**WELWYN HATFIELD BOROUGH COUNCIL
EXECUTIVE DIRECTOR - PLANNING, PUBLIC PROTECTION AND GOVERNANCE**

DELEGATED APPLICATION

Application No: 6/2019/0767/HOUSE
Location: 9 Stanborough Mews Welwyn Garden City AL8 6DB
Proposal: Erection of a single storey rear extension and partial conversion of existing garage
Officer: Mr A Commenville

Recommendation: Granted

Drawing No: 4645-P01 Revision: A

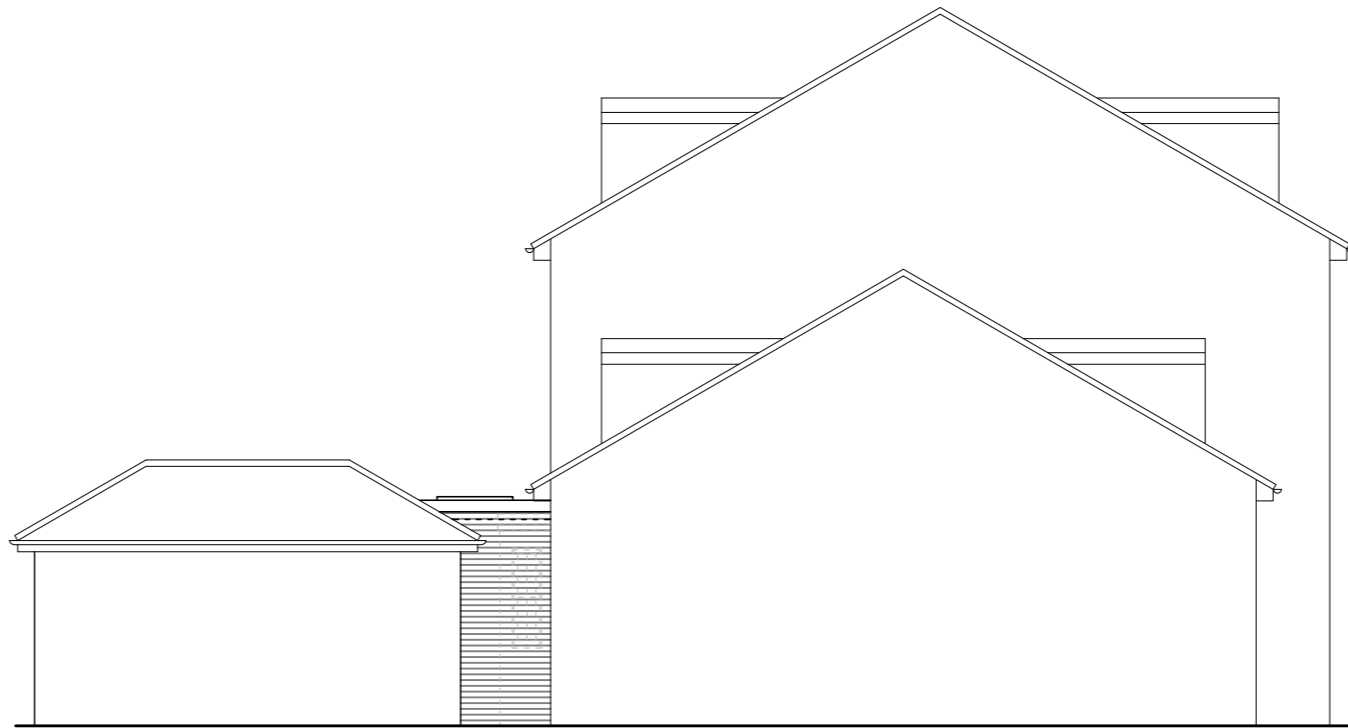
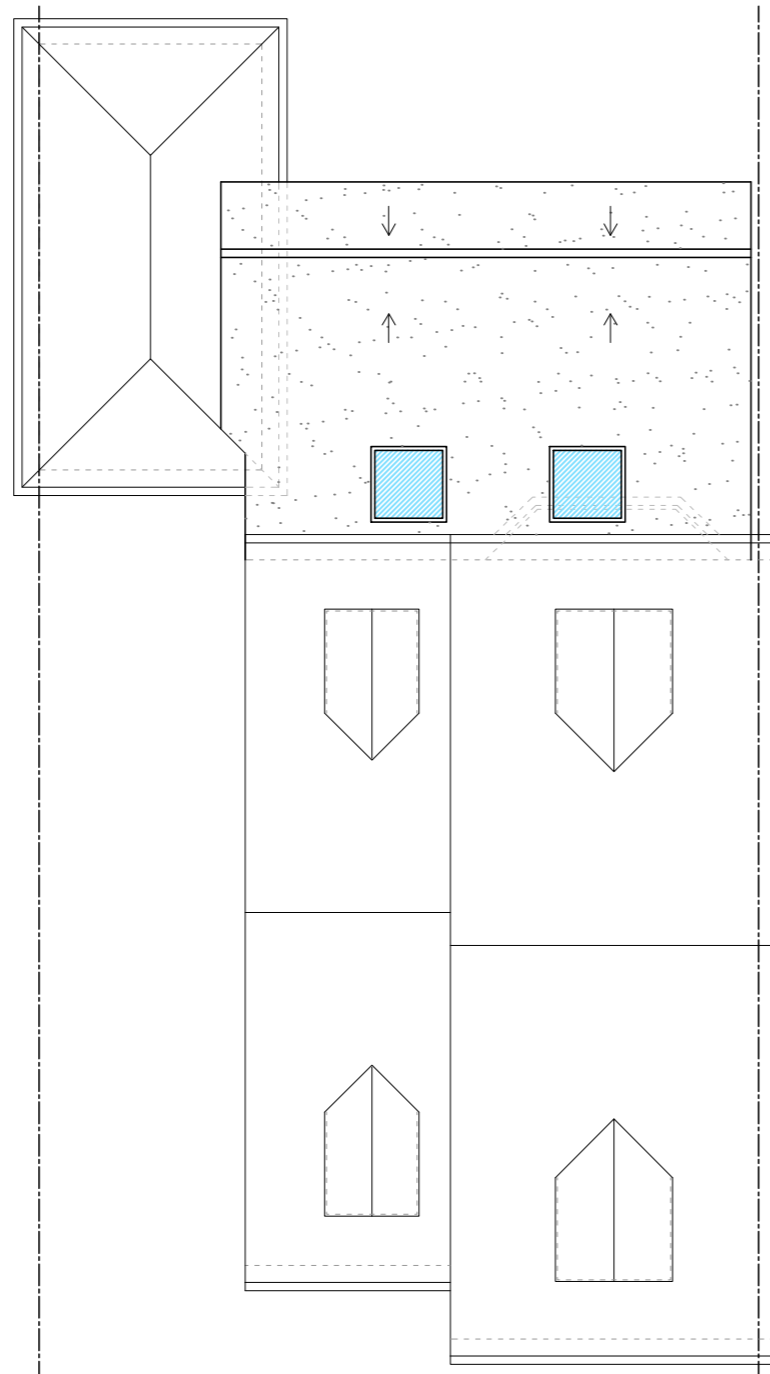
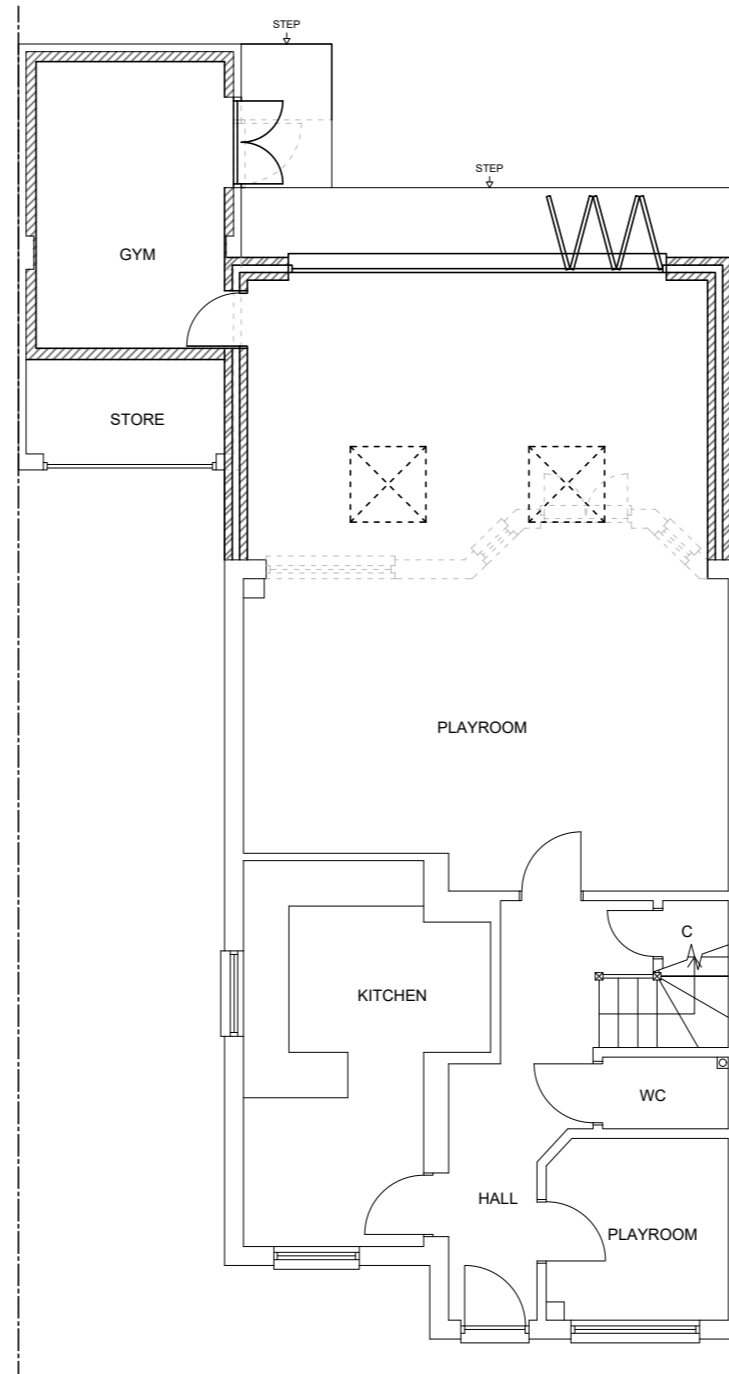
Context			
Site and Application description	<p>9 Stanborough Mews is a two storey semi-detached property with a detached garage and driveway.</p> <p>The applicant is seeking planning permission for the erection of a single storey rear extension which would measure 4 m in depth, 3 m in height with a flat roof and span the full width of the existing dwellinghouse.</p> <p>The proposal also include the conversion of garage into habitable room.</p>		
Constraints (as defined within WHDP 2005)	<p>CA - Conservation Area: WGC1; - Distance: 19.68</p> <p>EM - Estate Management - Distance: 0</p> <p>Wards - Handside - Distance: 0</p> <p>CP - Cycle Path (National Cycle Network) - Distance: 9.83</p> <p>CP - Cycle Path (Cycle Facility / Route) - Distance: 9.83</p> <p>HPGU - Hatfield Woodhall - Distance: 0</p>		
Relevant planning history	<p>Planning</p> <p>Application Number: 6/2019/0783/EM Decision: Decision Date:</p> <p>Proposal: Erection of a single storey rear extension and partial conversion of existing garage</p>

Would the development provide / retain sufficient parking?	
<input checked="" type="checkbox"/> Yes <input type="checkbox"/> No <input type="checkbox"/> N/A Comment (if applicable): It is noted that one garage space would be lost. However, the application site benefits from at least three parking spaces and the proposal is therefore considered to be in accordance with policy M14 of the Welwyn Hatfield District Plan, 2005.	
Any other issues	
Conclusion

The proposed development is of a high quality and respects and relates to the character and context of the area in which it is proposed. Whilst not within the conservation area it is within sight of the boundary of the conservation area, it is however considered that the rear single storey extension will not have a significant impact on the setting of the conservation area and so having regard to the LPA duty to pay special regard to the setting of the conservation area imposed by Section 72 of the Planning (Listed Buildings and Conservation Areas) Act, the proposal is considered acceptable. The proposal retains a satisfactory relationship with adjoining neighbours and provides parking for one vehicle. No objections are therefore raised with regard to the NPPF or the Welwyn Hatfield District Plan, SDG, SPG or Interim Policy for Car Parking Standards and Garage Sizes.

1. The brickwork, bond, mortar, detailing, guttering, soffits and other external decorations of the approved extension must match the existing dwelling in relation to colour and texture.
